From: [Jennifer Sokolowski](#)
To: [Rachael Stevie \(CD\)](#)
Subject: RU-22-00002 East Peak
Date: Wednesday, April 13, 2022 10:57:36 AM
Attachments: [image002.png](#)
[image003.png](#)
[image004.png](#)

If these new residences or condos are coming, RU-22-00002 East Peak, I would ask that a road is established on the east side of their property. This would allow access to Sundance north entrance for a turn around for Sundance. The parking at Hyak is horrendous and this could help divert some of the traffic for the new places and allow better access for emergency vehicles. This could be a win/win for everyone.

Reasonable Use - RU-22-00002 East Peak

EXHIBIT A - PROPOSED SITE PLAN

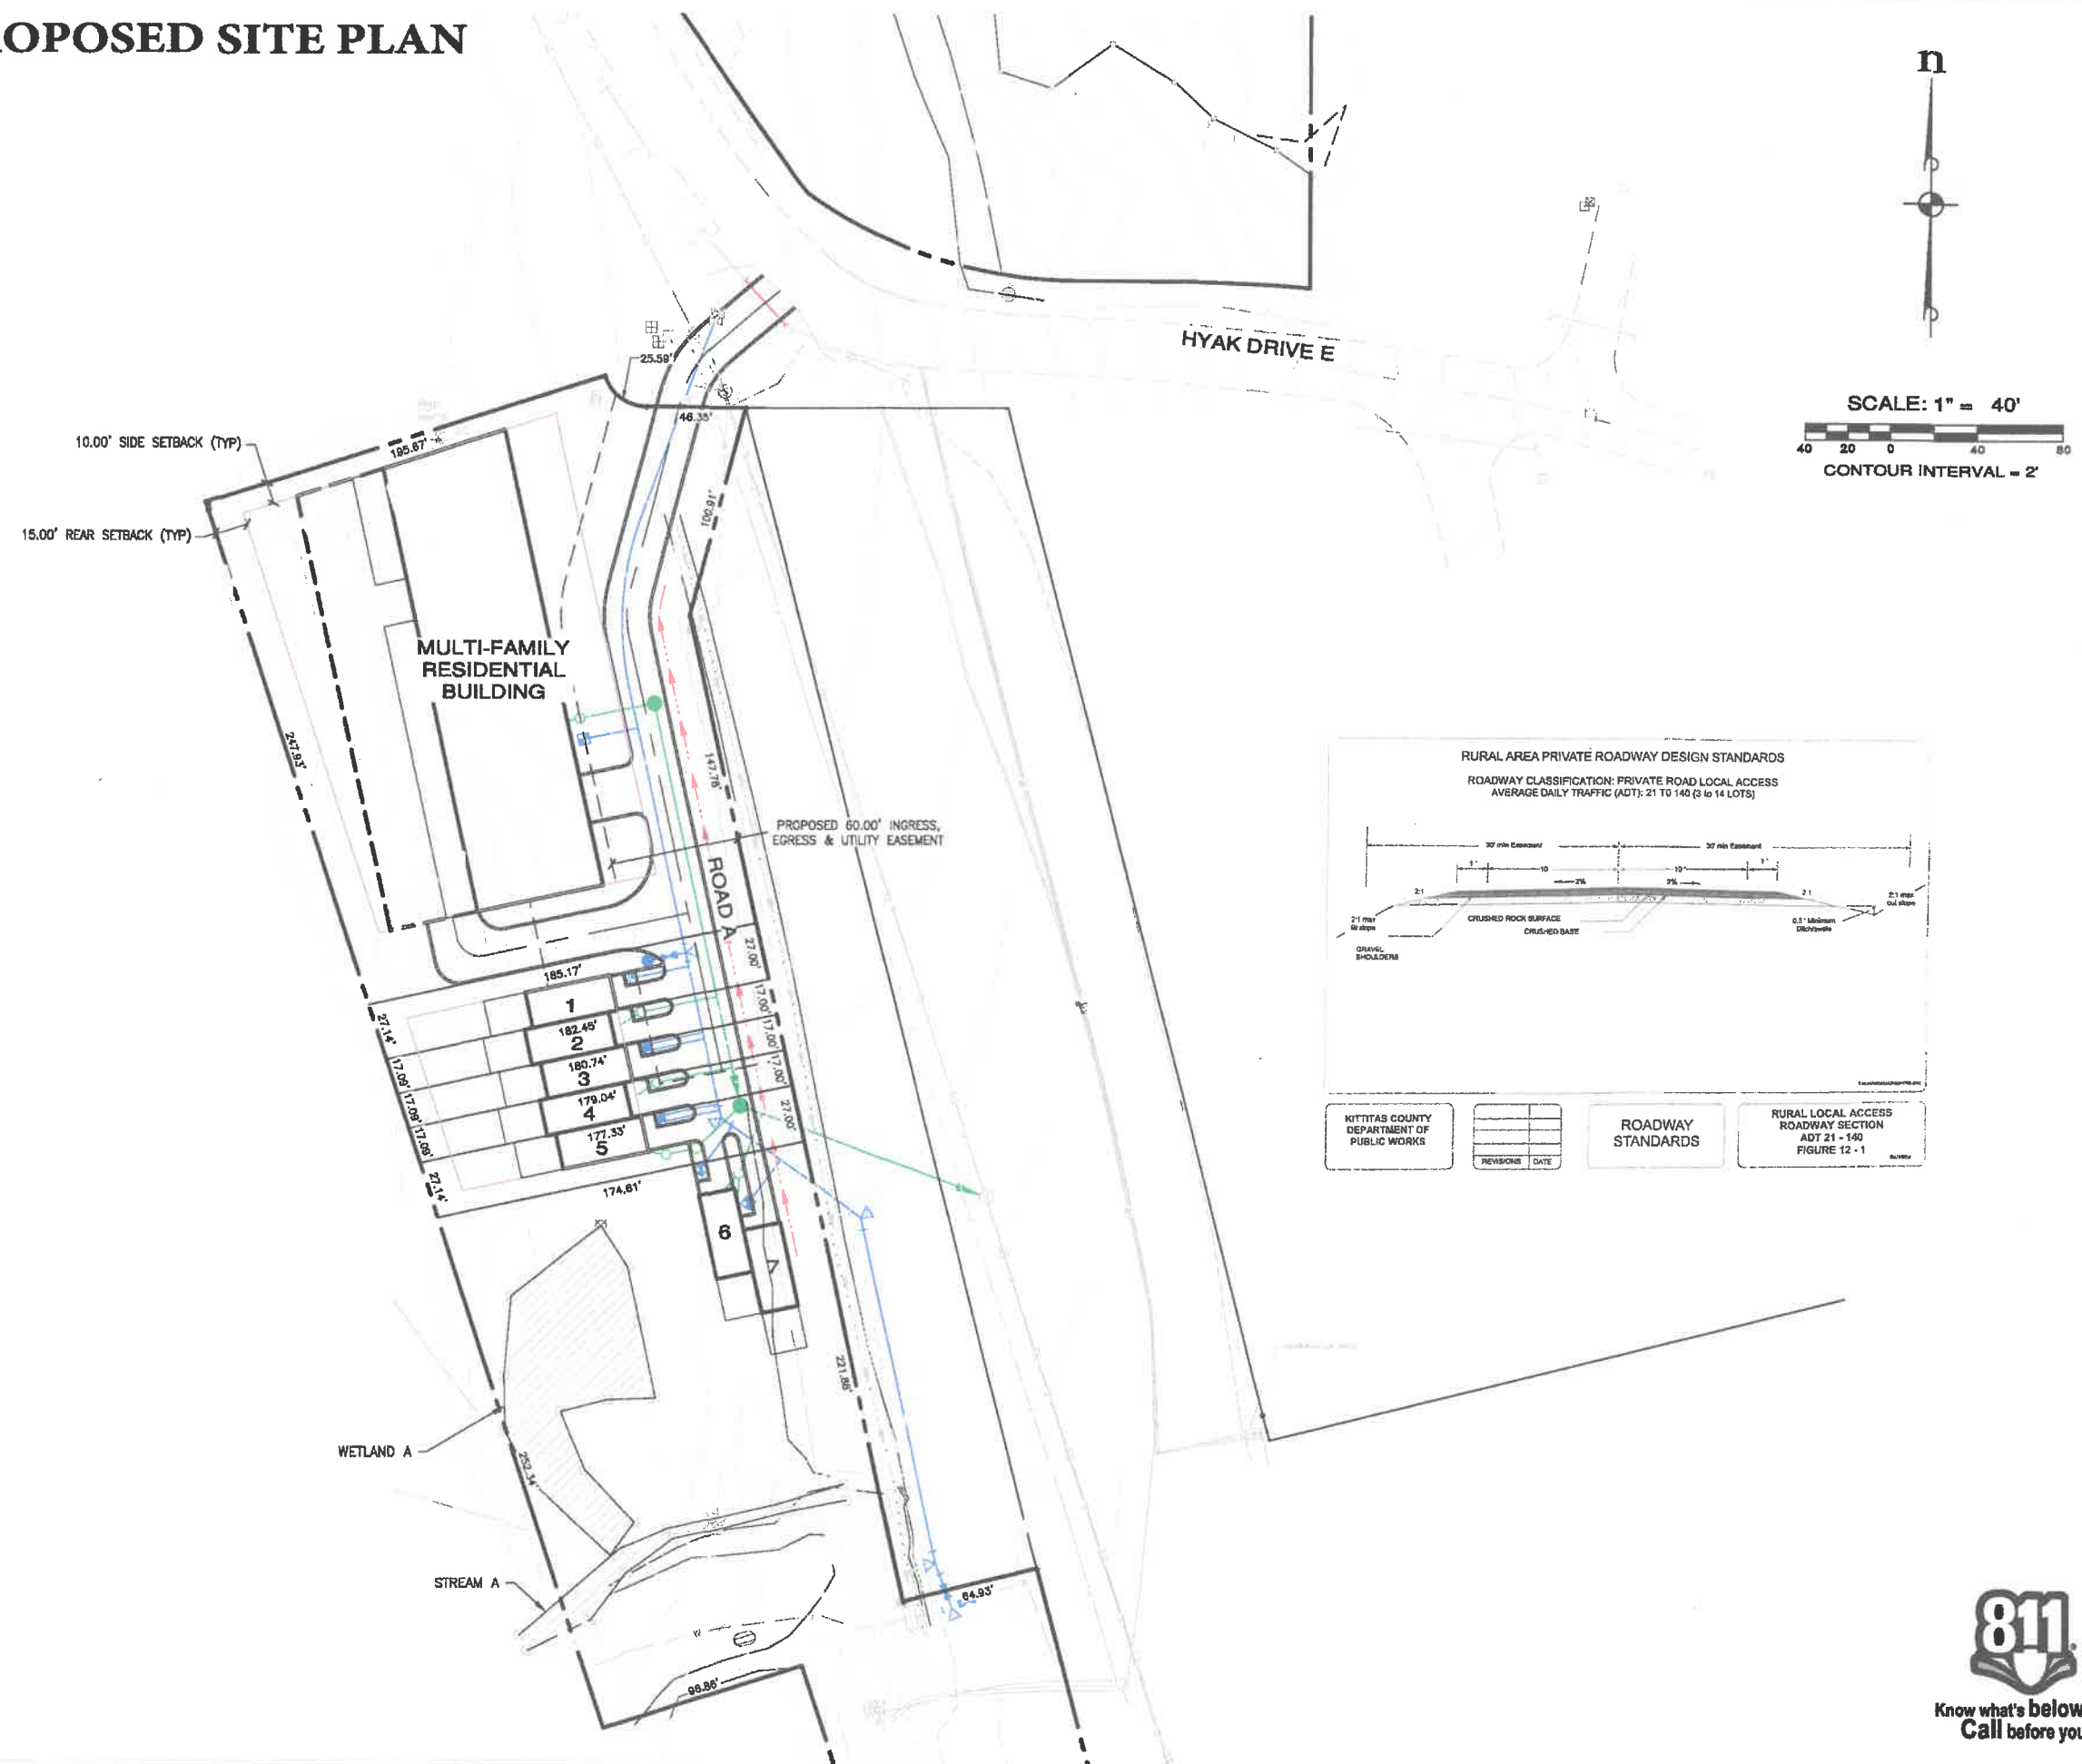
I'd like to ask them if there is any way to get additional access to our building if their street comes close to our building. Meaning it would be nice if a road is coming maybe we could have a drop off turnaround site at the north entrance of our building.
